Our Case Number: ACP-324383-26

Re: Proposed IDA Belview Infrastructure Development
Belview, Slieverue, County Kilkenny

SID Online Observation

Our observations relate specifically to the section of the application concerning the IDA Kilmurry landbank.

Title: **Proposed Access Road Layout Masterplan**

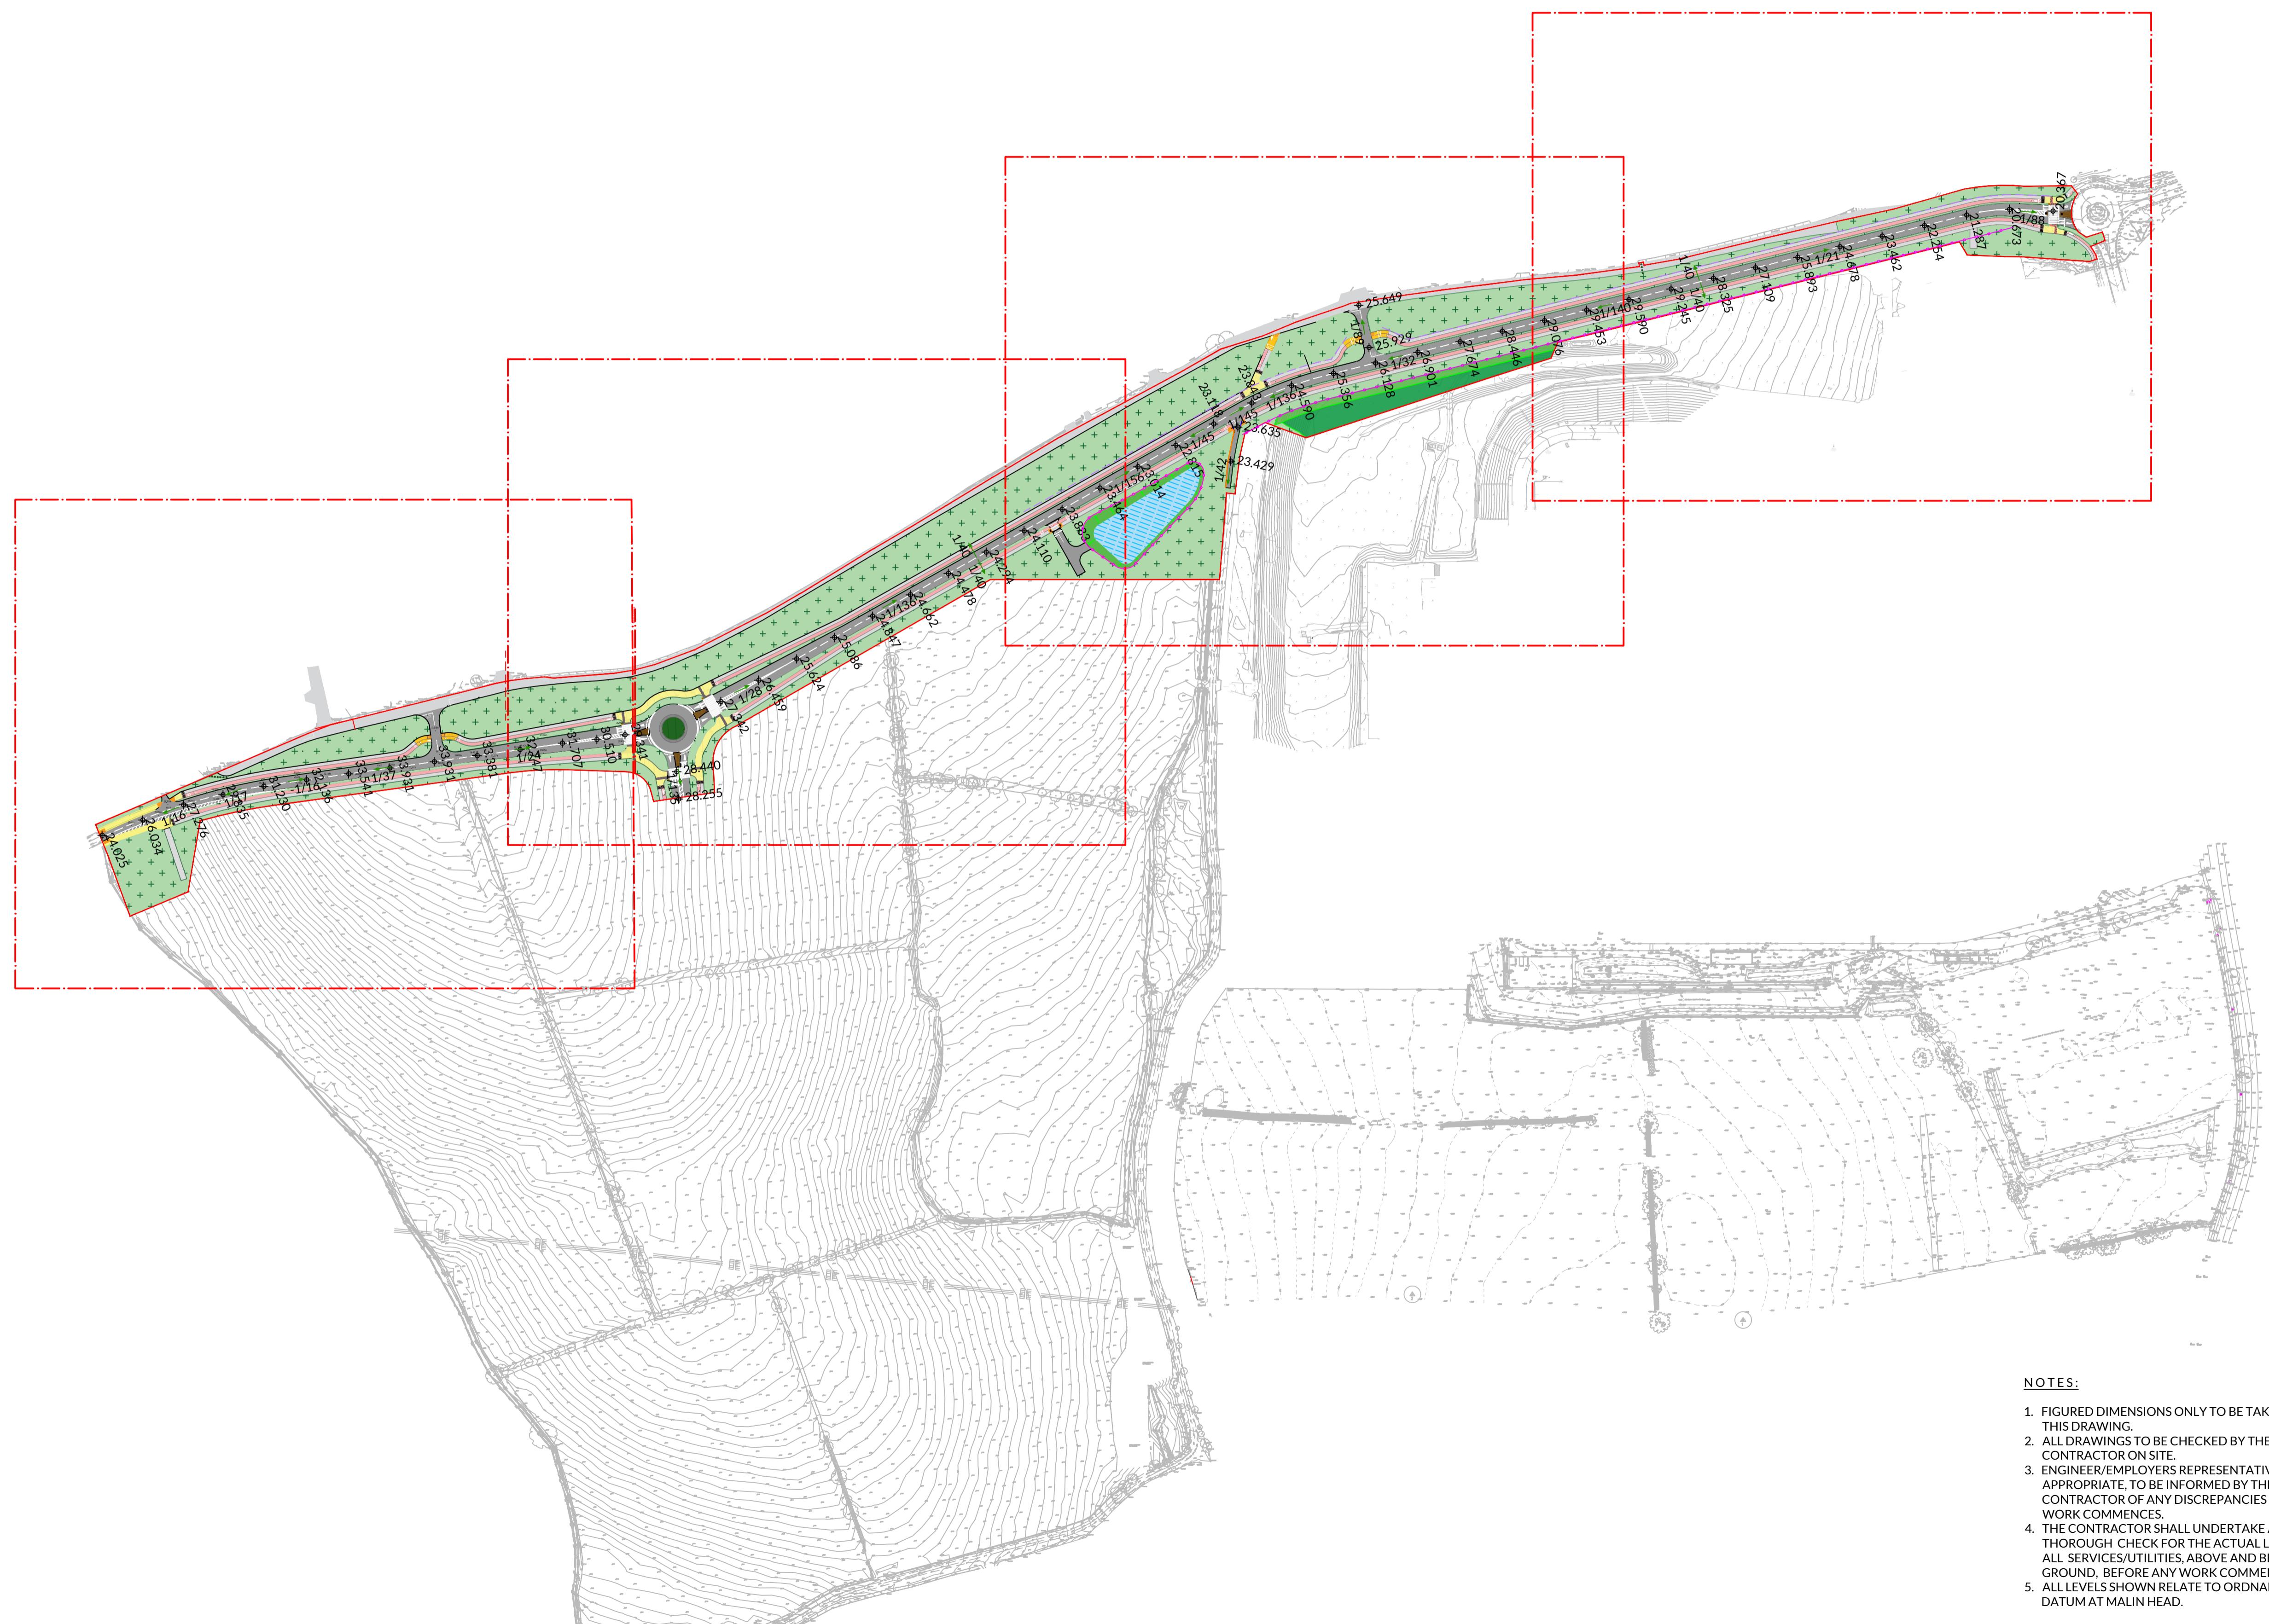
All residents along the proposed road realignment bordering the IDA Kilmurry landbank have had their properties set back from directly facing IDA land, with one exception: house X91 X8Y2, for which a separate, standalone access road is being built. This appears both unnecessary and unsafe, particularly as this section of road narrows to align with the existing road. We request that An Coimisiún Pleanála consider the long-term safety implications for this property and require it to be brought within the cul-de-sac instead, for the safety of the residents, cyclists, pedestrians, and other road users. If the application is approved, we ask that this be addressed by condition.

We also note that there are already five egress/entry points between Gyles Quay Road and the new roundabout. Every effort should be made to consolidate access points rather than add further ones.

In addition, the landowner adjacent to this house does not appear to have retained access to the L3412 entry point.

Title: **Proposed Access Road Layout Sheet 1 of 2**

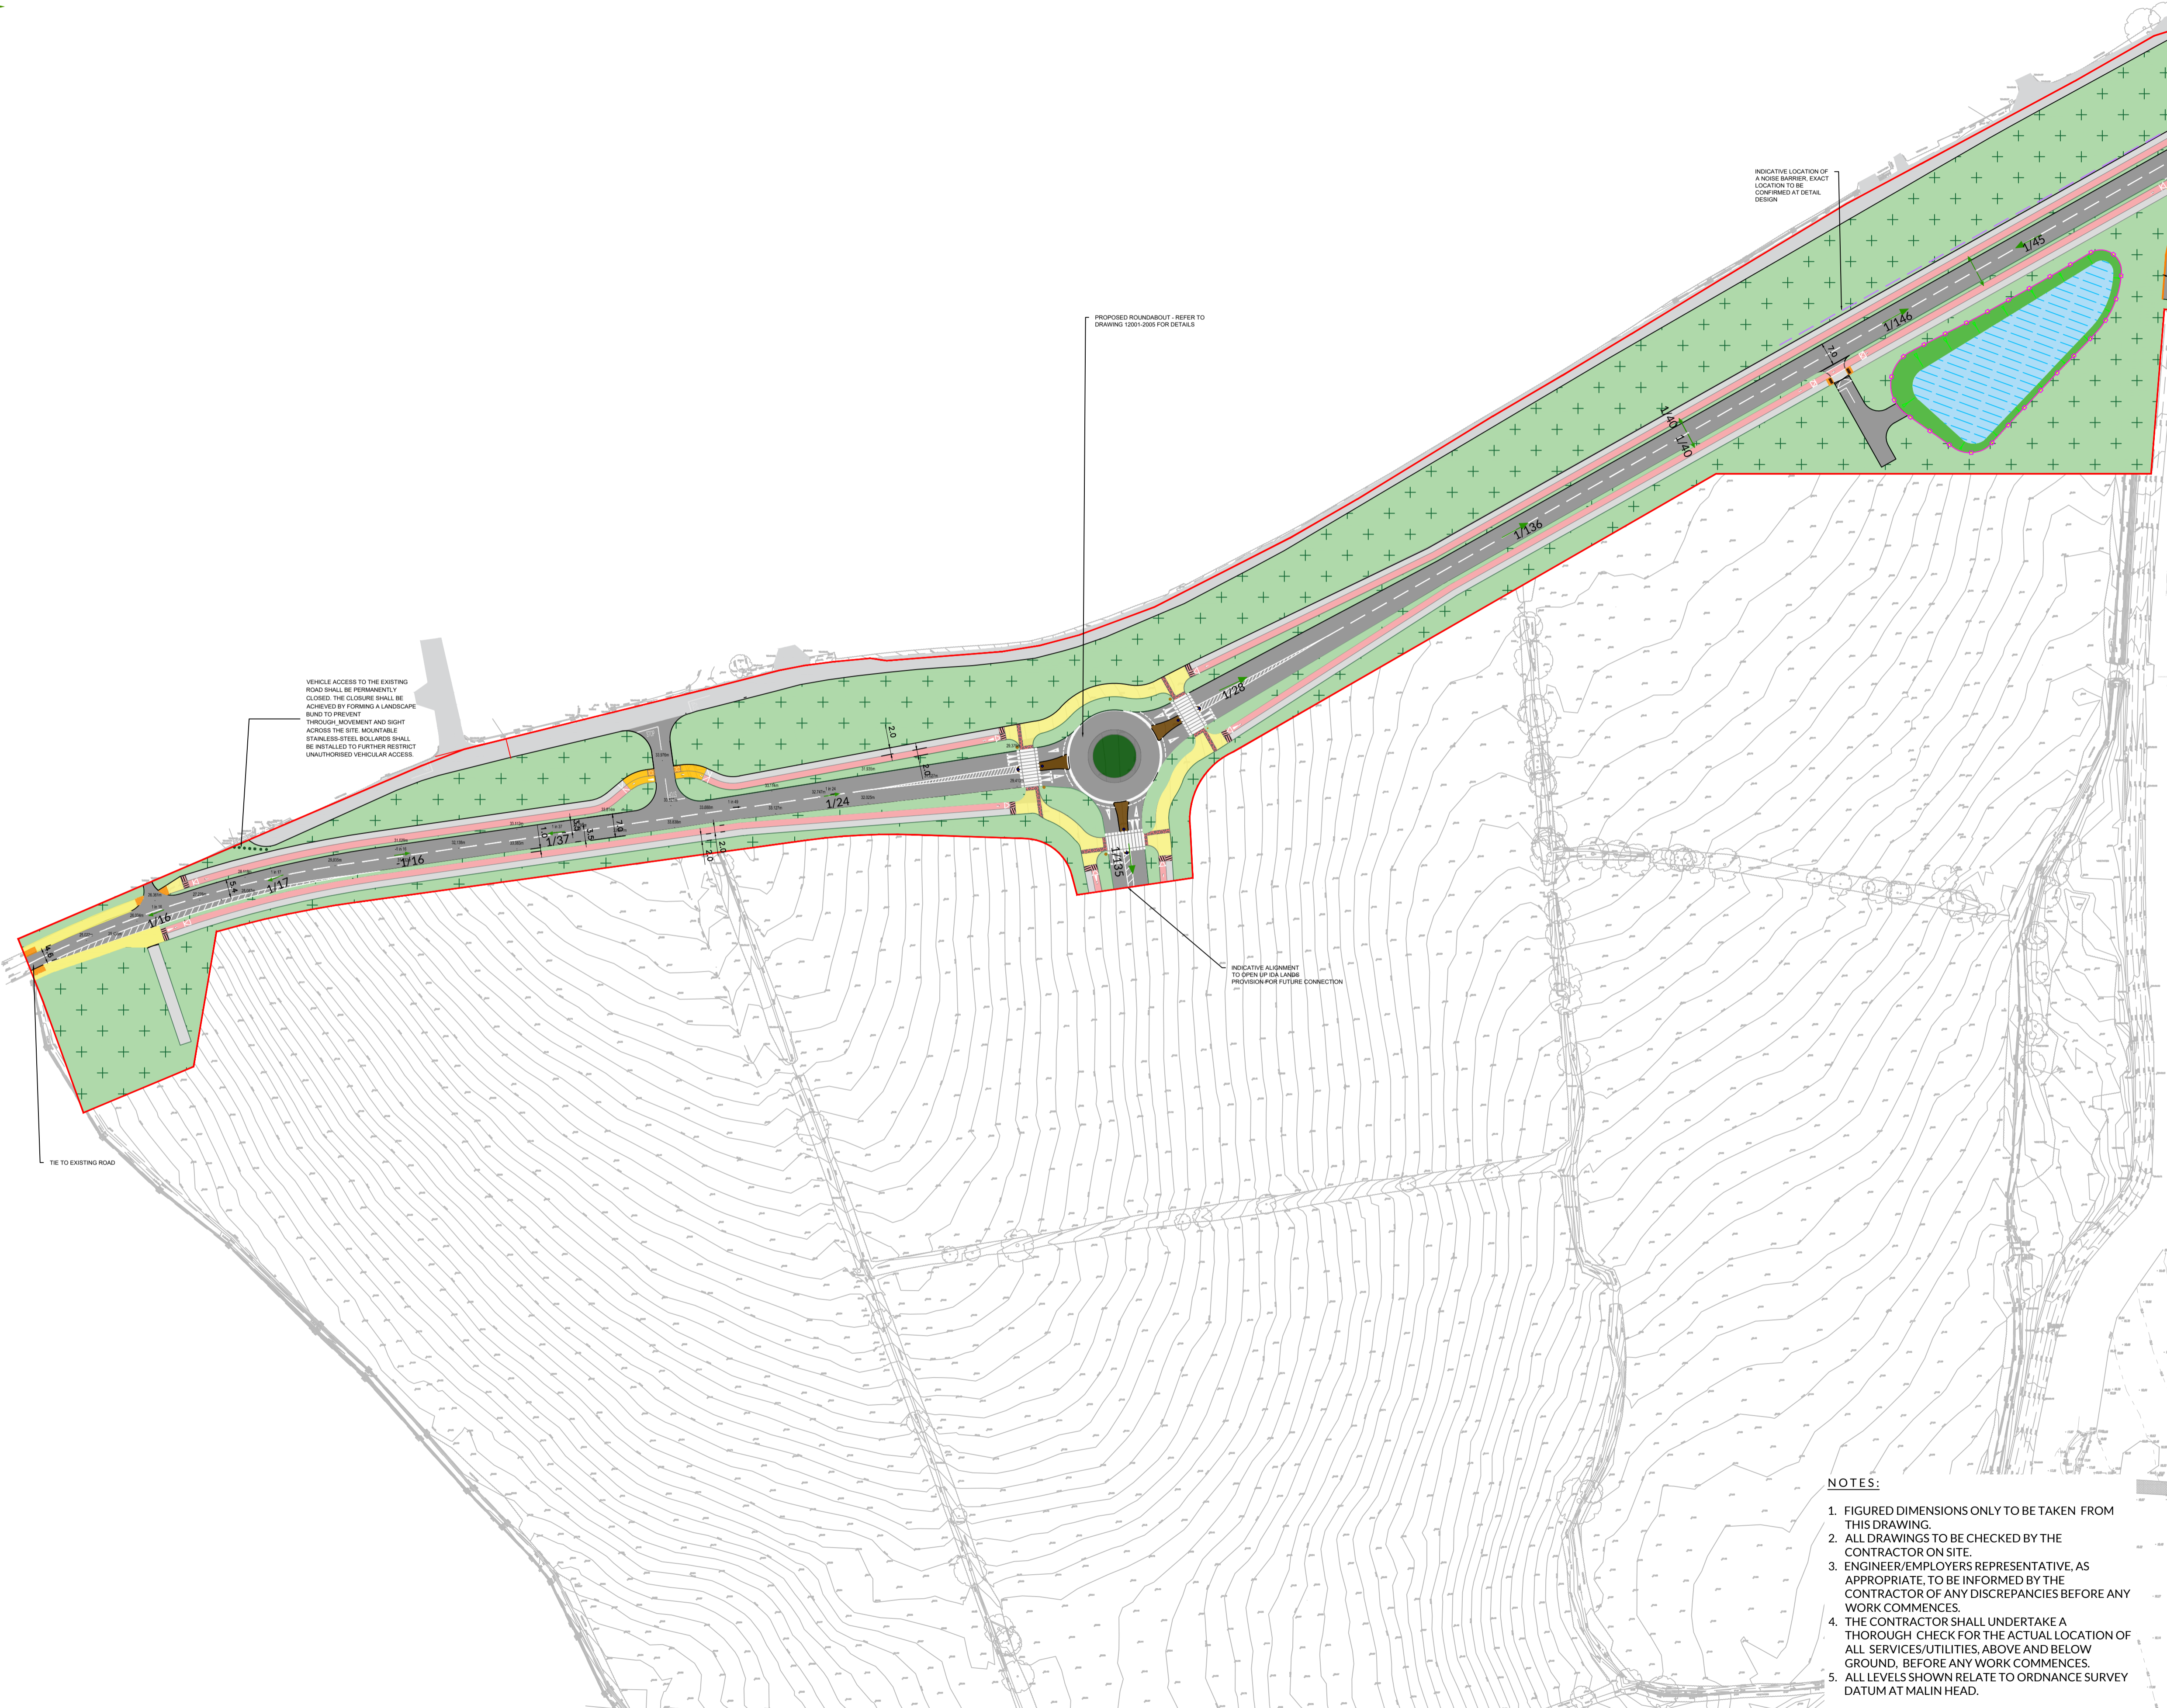
- **Proposed noise barrier mitigation is incomplete and not yet committed to:** Where noise barriers are shown, they appear in short, disconnected sections, marked only as "indicative" and "to be confirmed at detail design." The assessment itself acknowledges that some nearby receptors will remain significantly affected even after the proposed barrier is built, as they fall outside its coverage.

1. That the noise assessment be extended to properly measure and model noise impacts for all residents facing the Kilmurry landbank; and
2. That a 2-metre high earthen mound be constructed, extending from the new roundabout as far west as possible, as a firm (not indicative) mitigation commitment. An earthen mound would provide effective long-term noise attenuation, a better visual/landscape outcome than a standard barrier, and will be well-matured by the design year (2040). This is a durable, cost-effective solution.
